**DEVIATION REQUEST  
AND DECISION FORM IN  
ASSOCIATION WITH A  
REQUEST FOR A PUD  
MODIFICATION FROM  
THE ECM**

Project Name : Waterside  
Schedule No.(s) : 71114-04-112  
Legal Description : All of the waterside condominiums subdivision, recorded in Plat Book 2, At Page 47 Records of El Paso County, Colorado

A deviation from the standards of or in Section **ECM2.2.4.B.7 (Figure 2-17), Table 2-7** of the Engineering Criteria Manual (ECM) is requested.

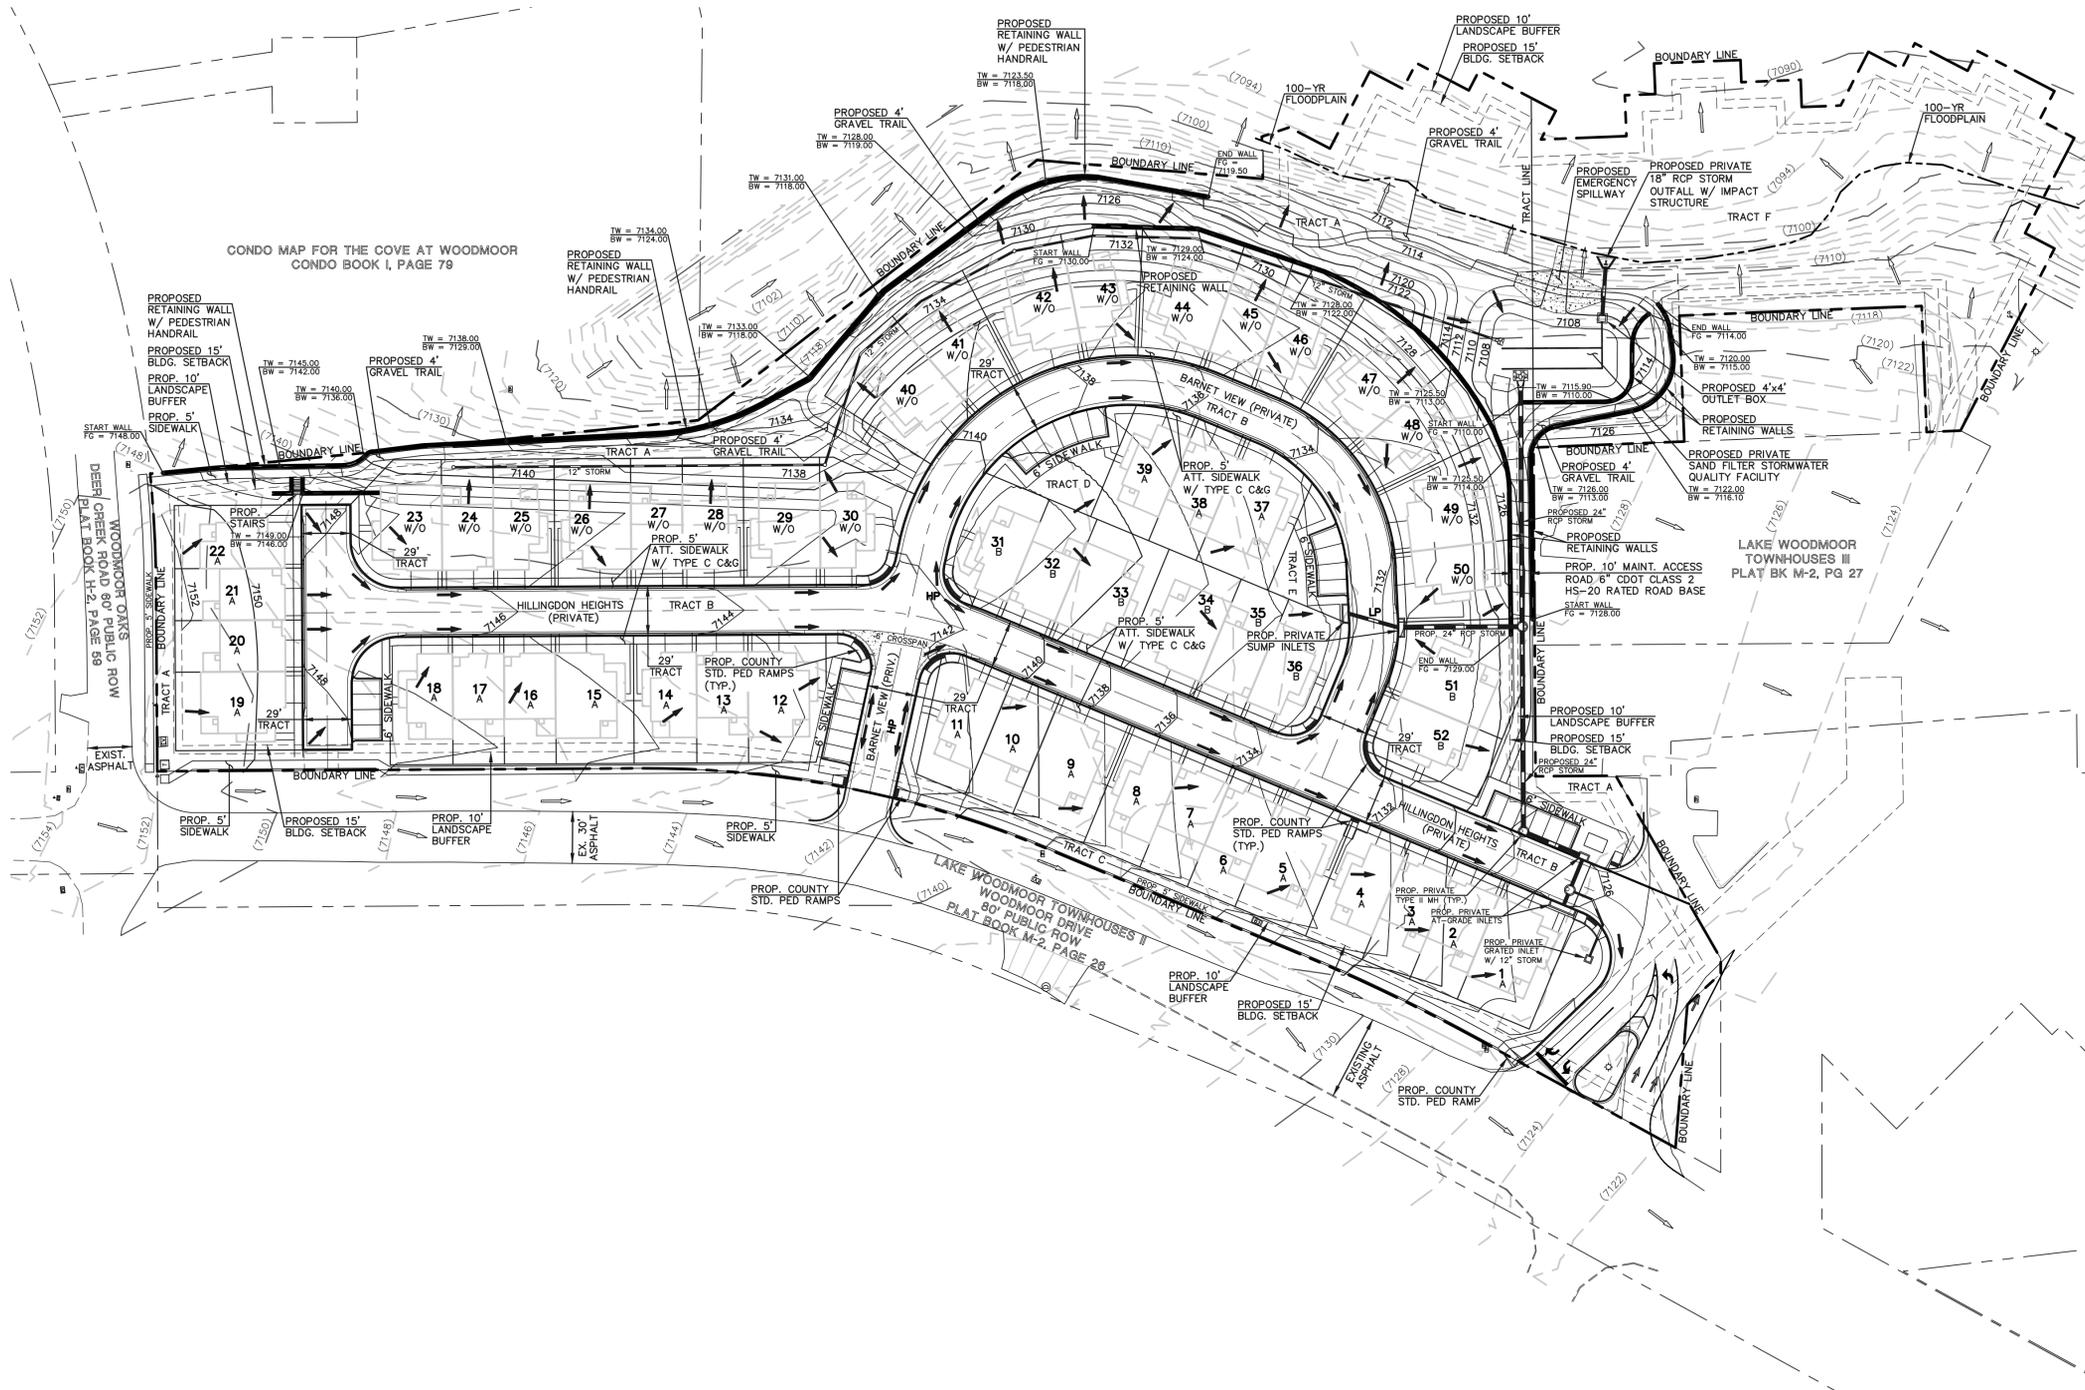
Include exhibit showing which roads are local and which one is low volume & provide street cross section.

Remove low volume.

29' per plans

Remove low volume
